ENG-PPR19009-R3-SDP.pdf Markup Summary

Subject: Callout
Page Index: 1
Date: 9/4/2019 2:23:30 PM
Author: dsdrice
Color: ■
Layer:
Space:
Page Label: [1] Layout1

WALKER ROAD PLAN &  
PROFILE

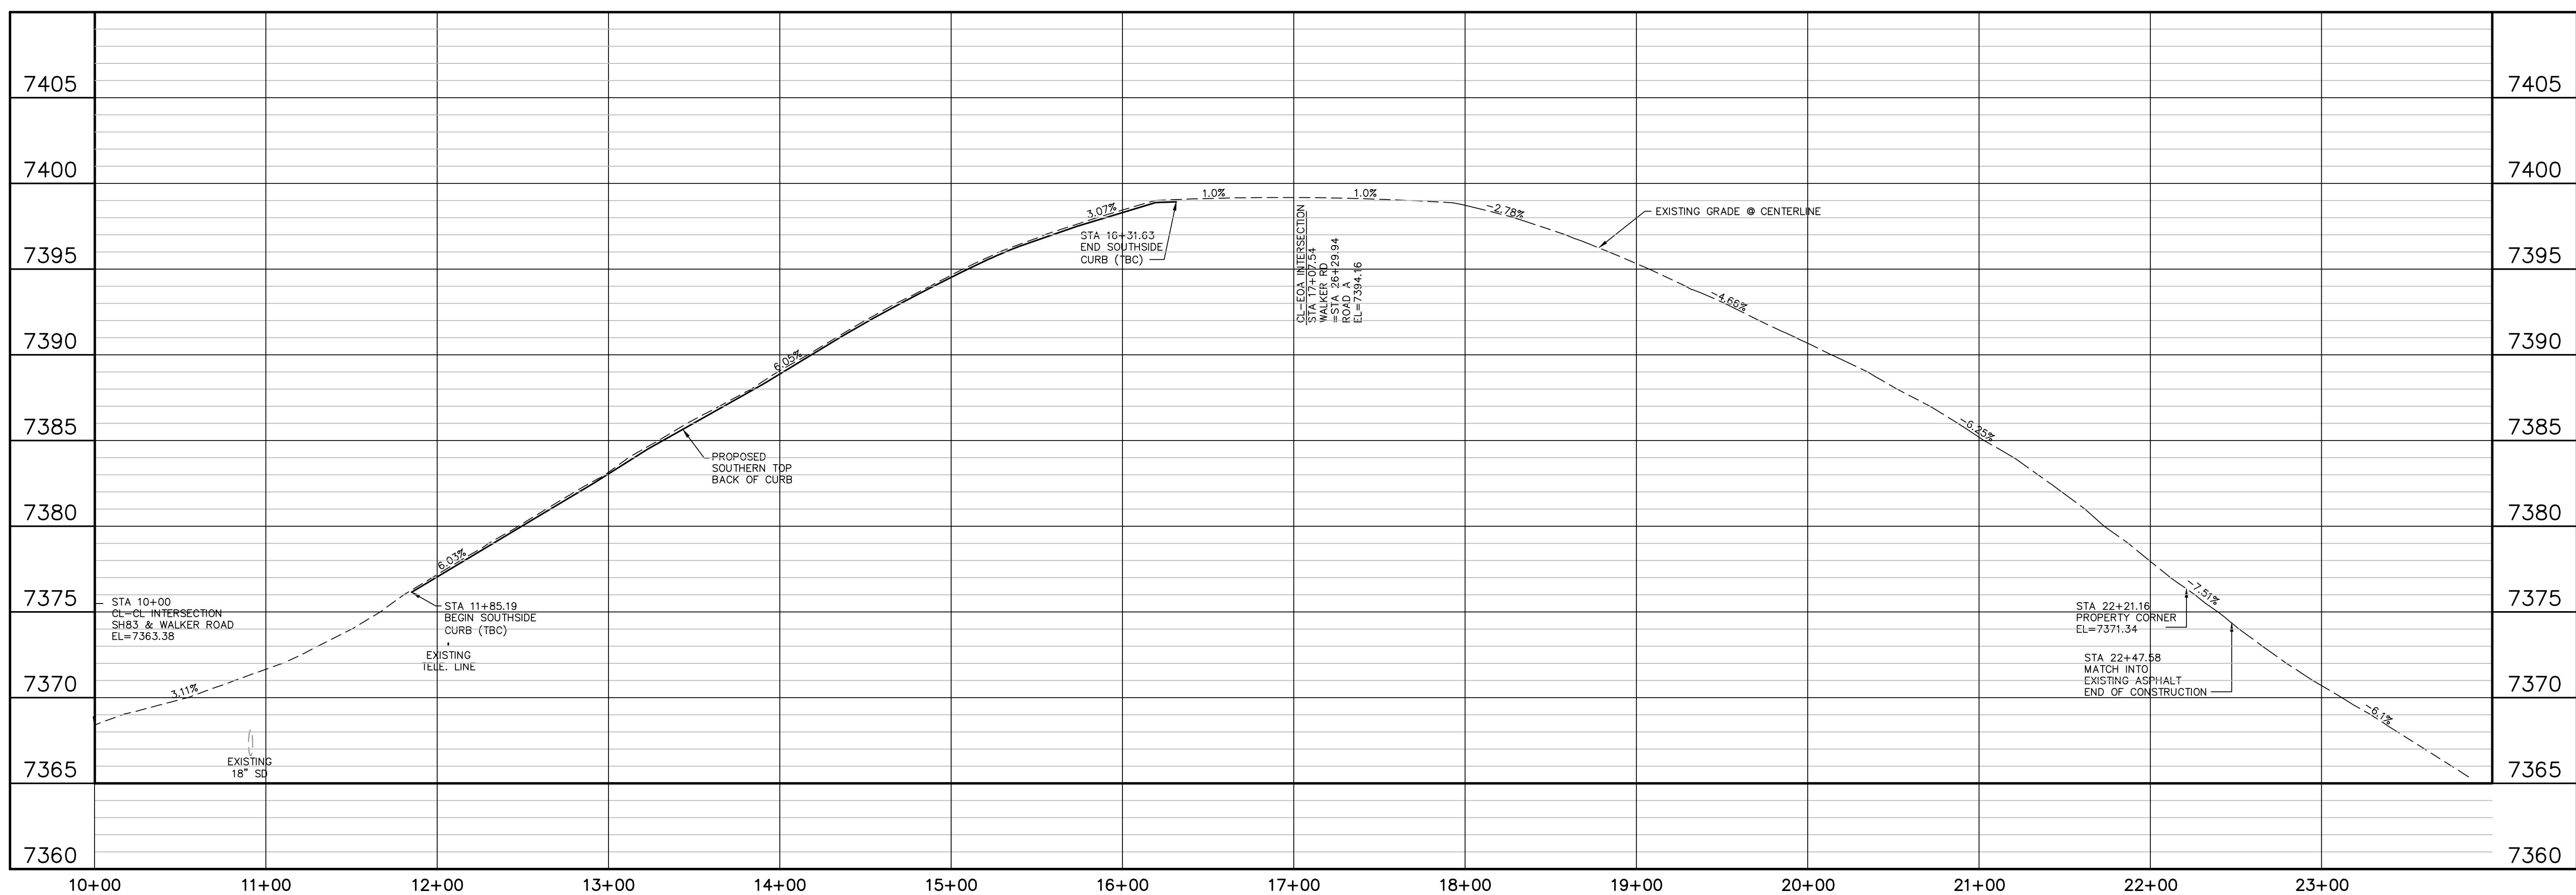
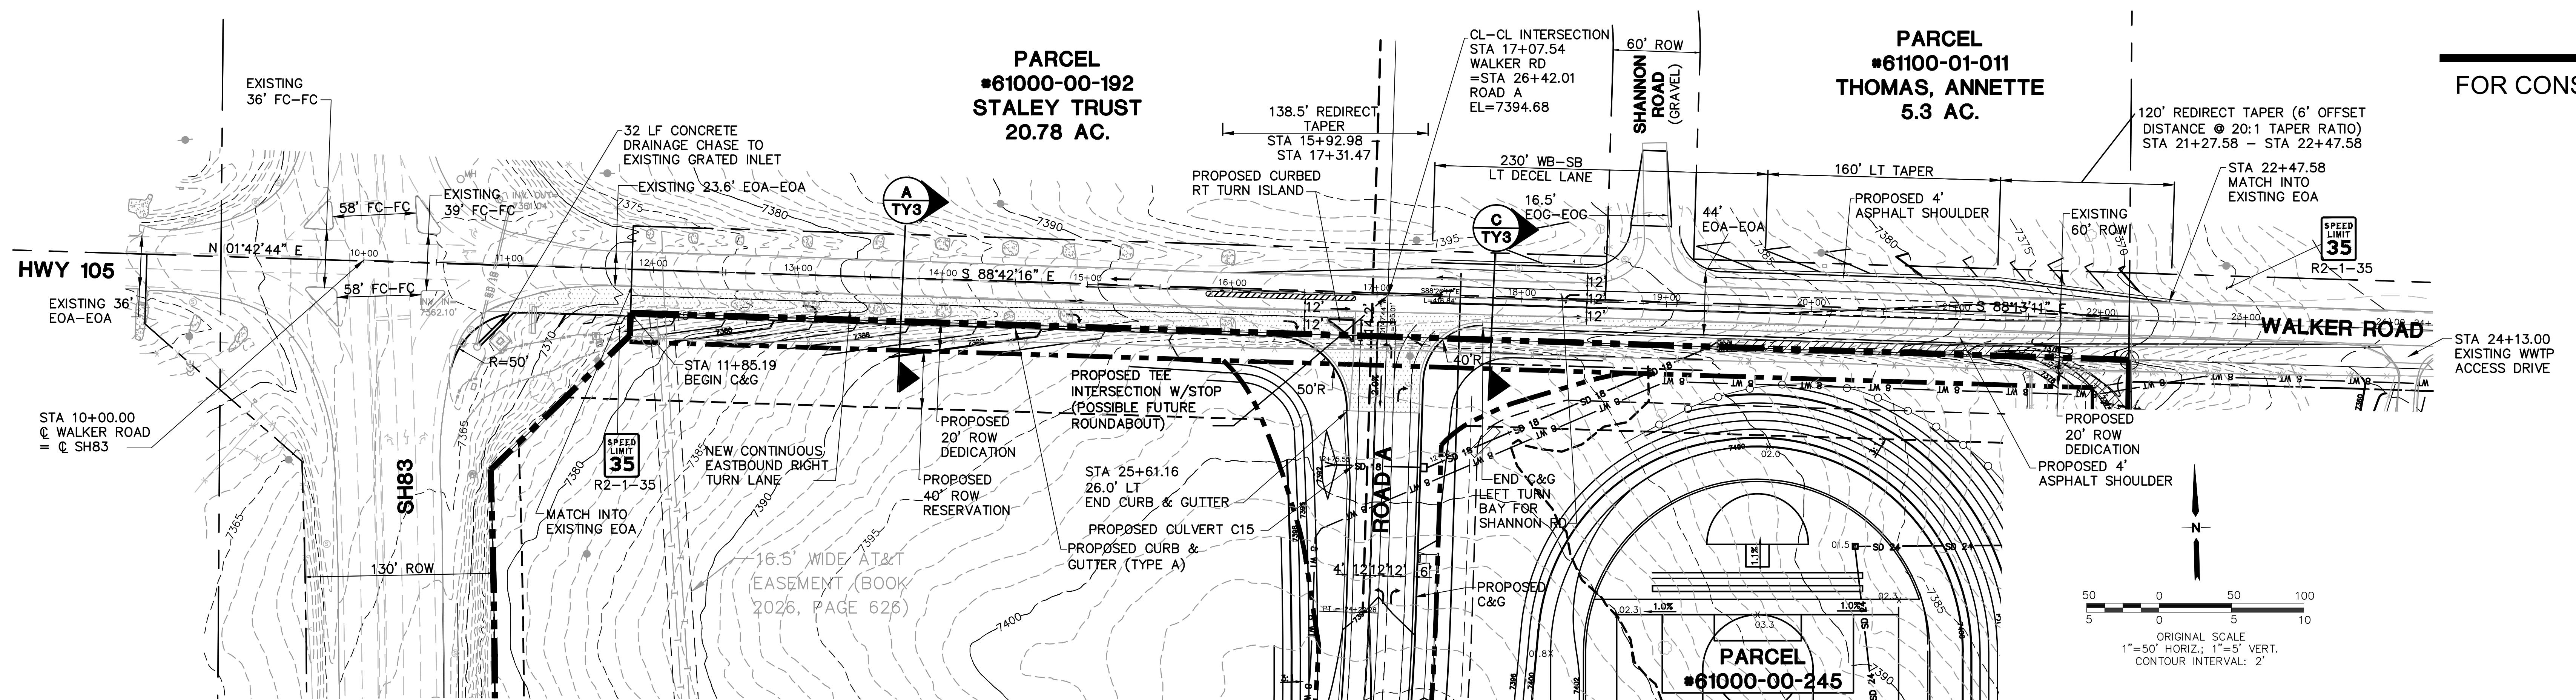
Connection to Walker Road is shown for information only. Walker Road improvement plans need to be approved by EPC prior to construction in the ROW. See Phase 1C GEC Plans.

**ROAD A PLAN & PROFILE**

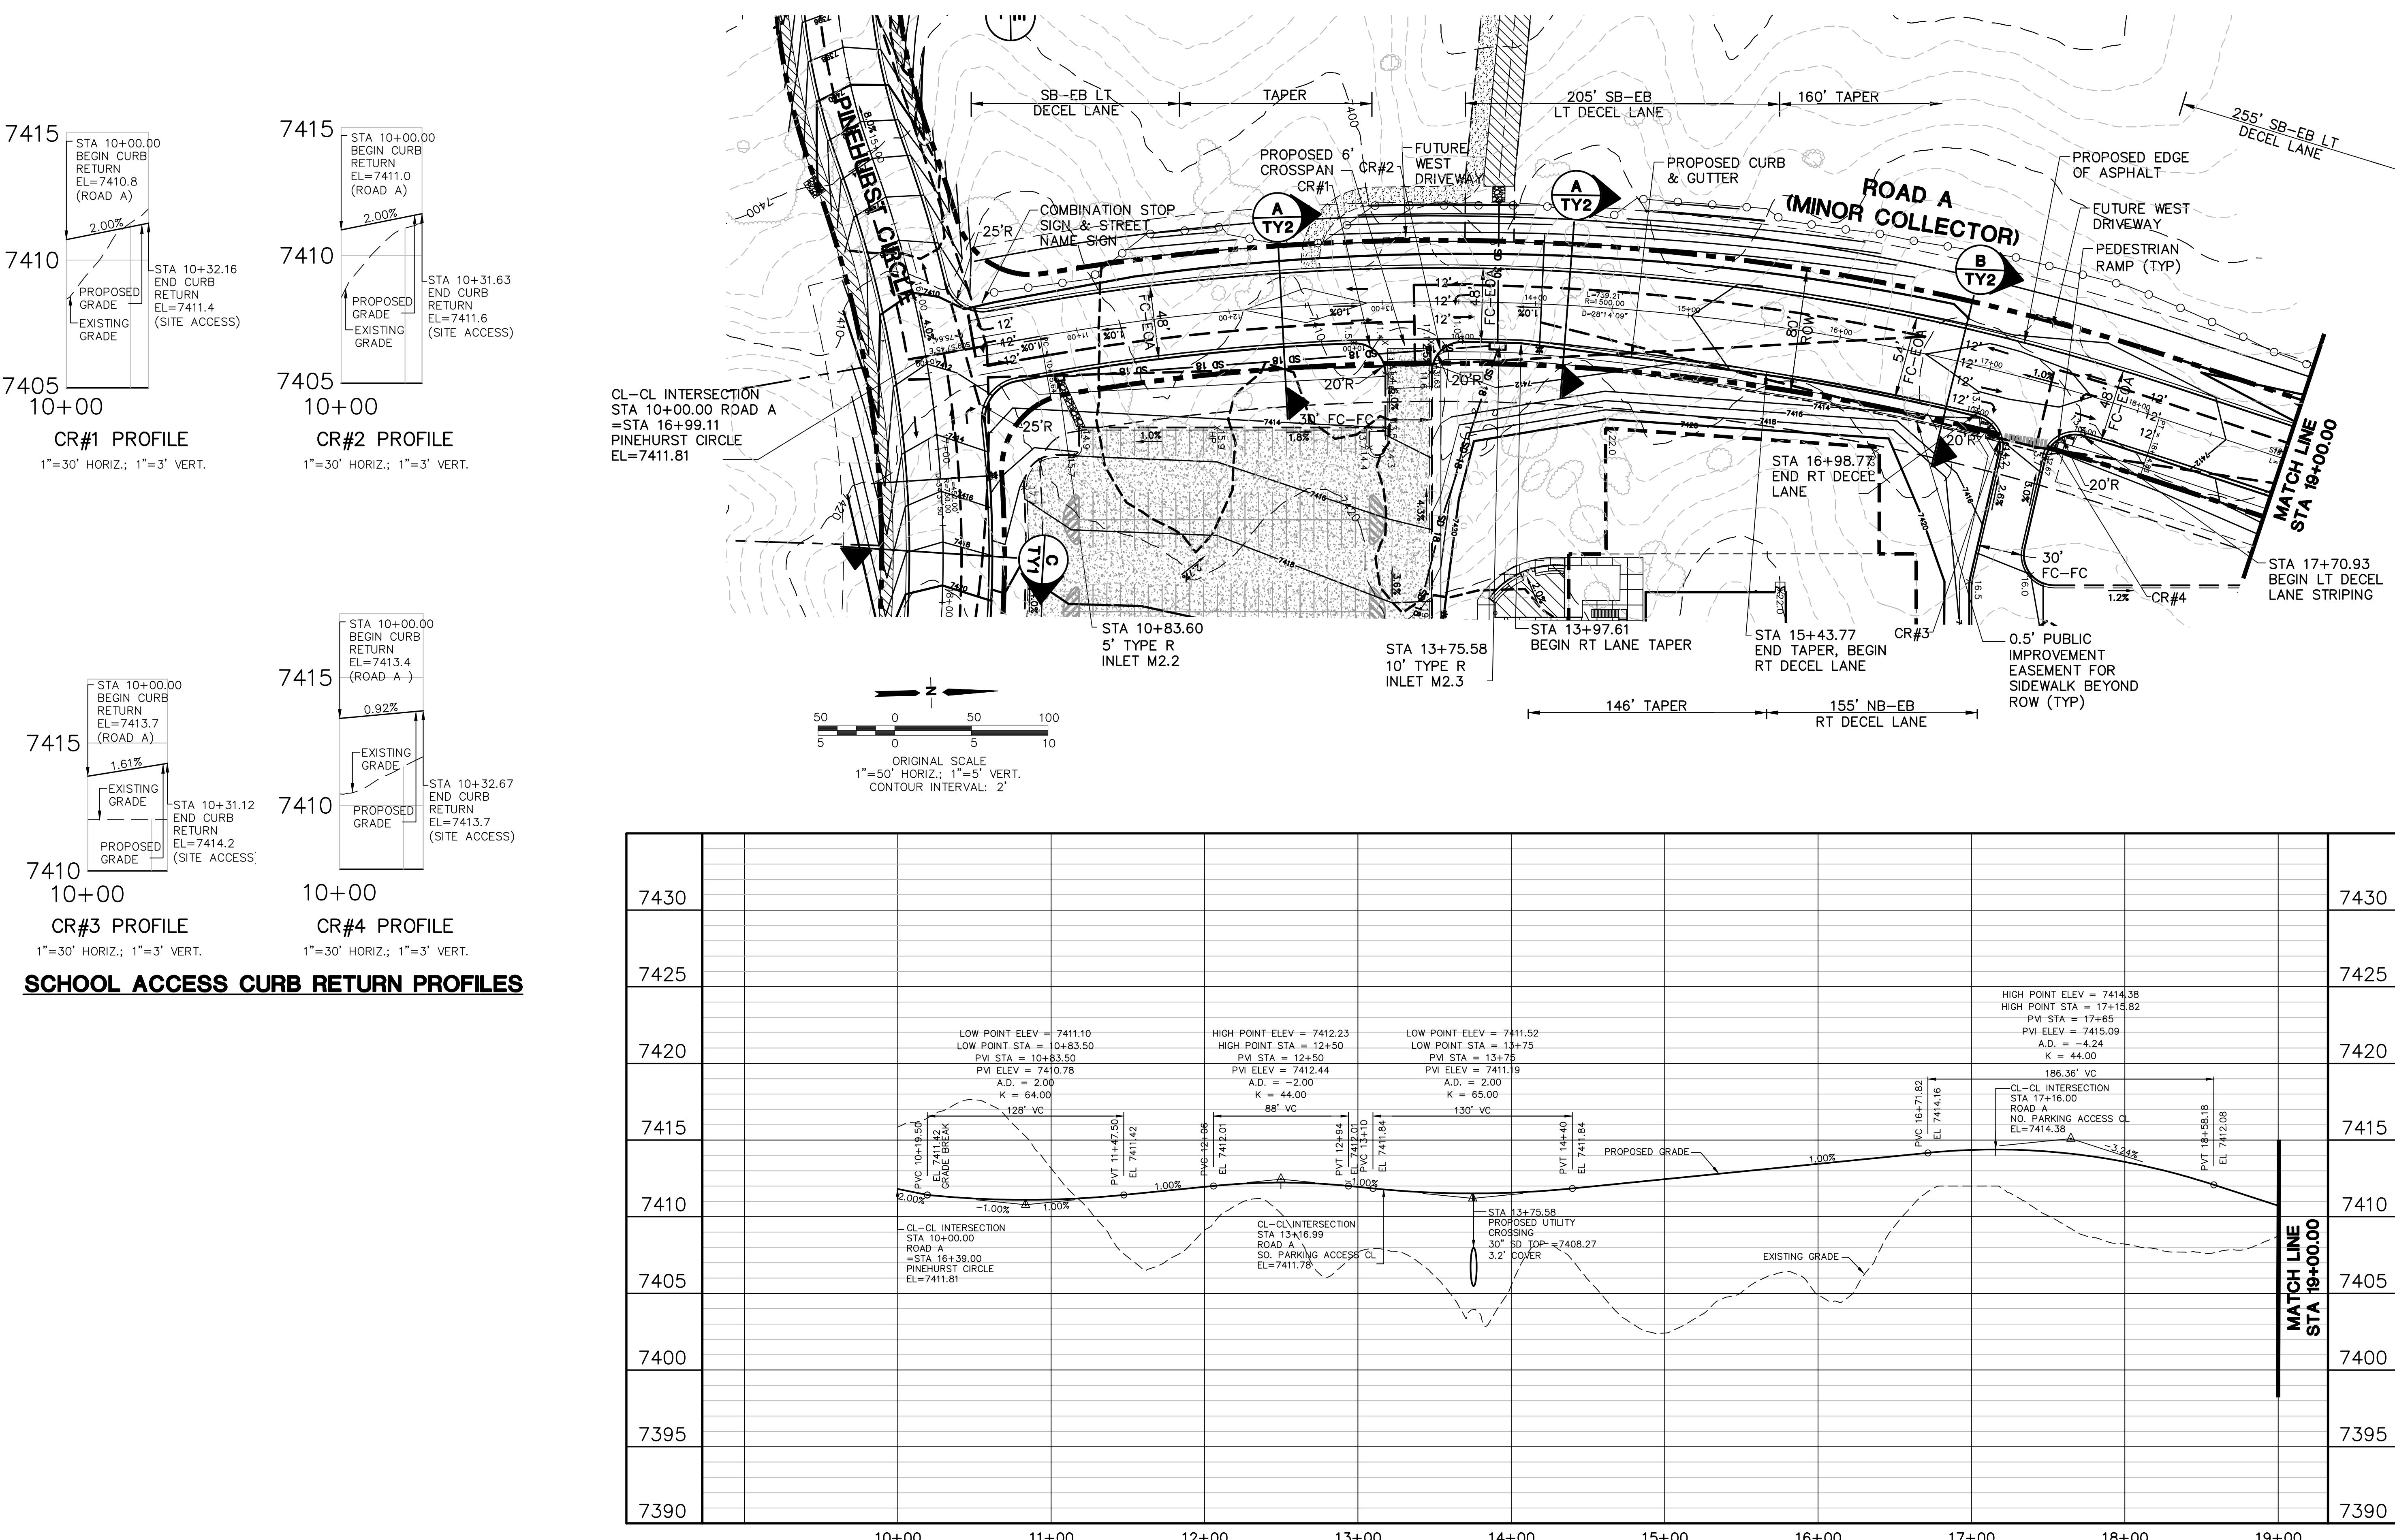
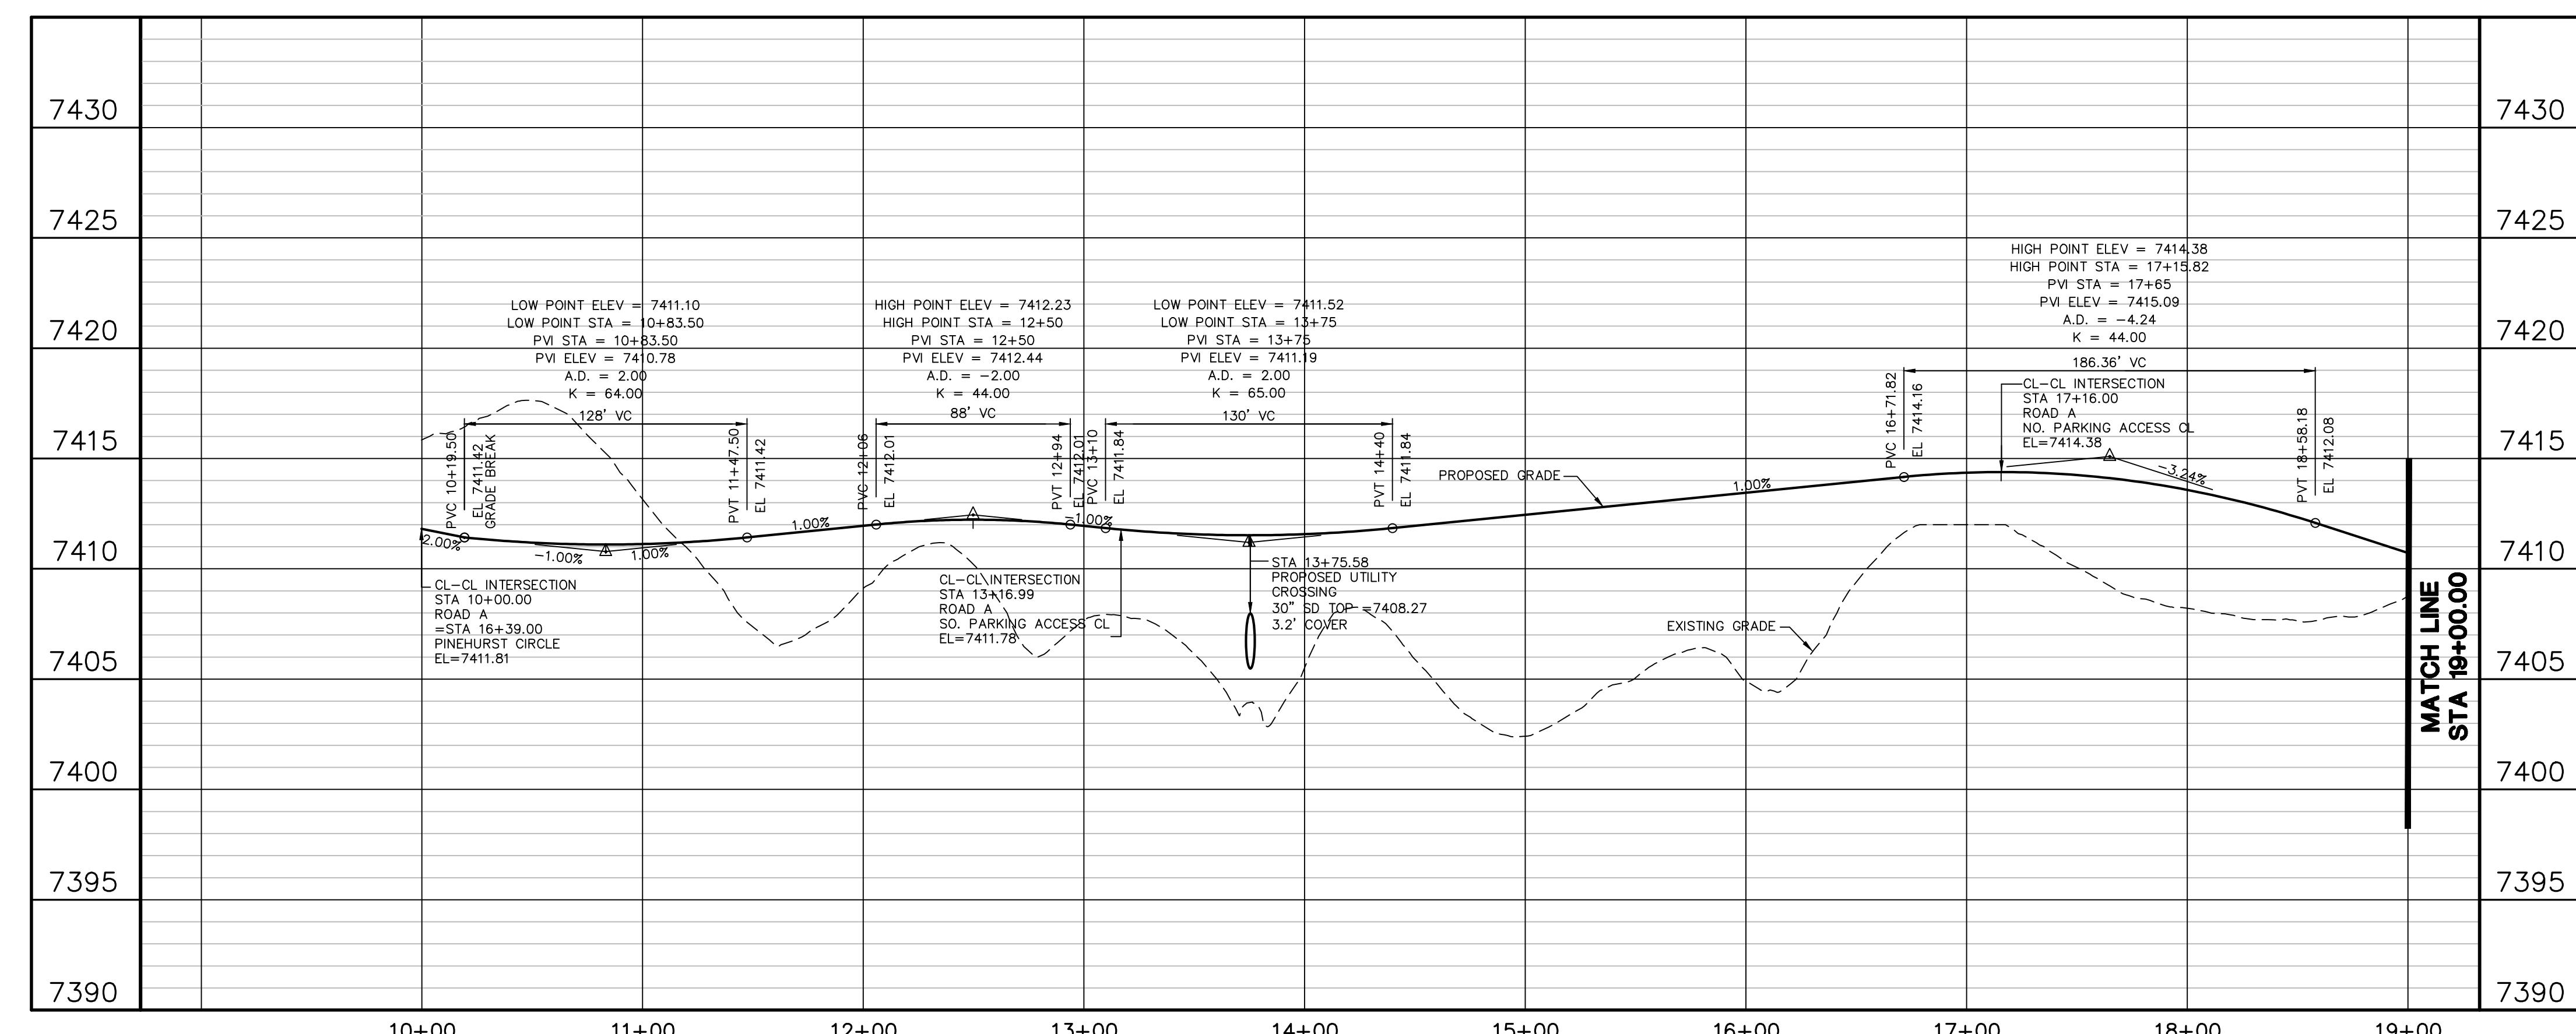
Is there an emergency or temporary access road here?
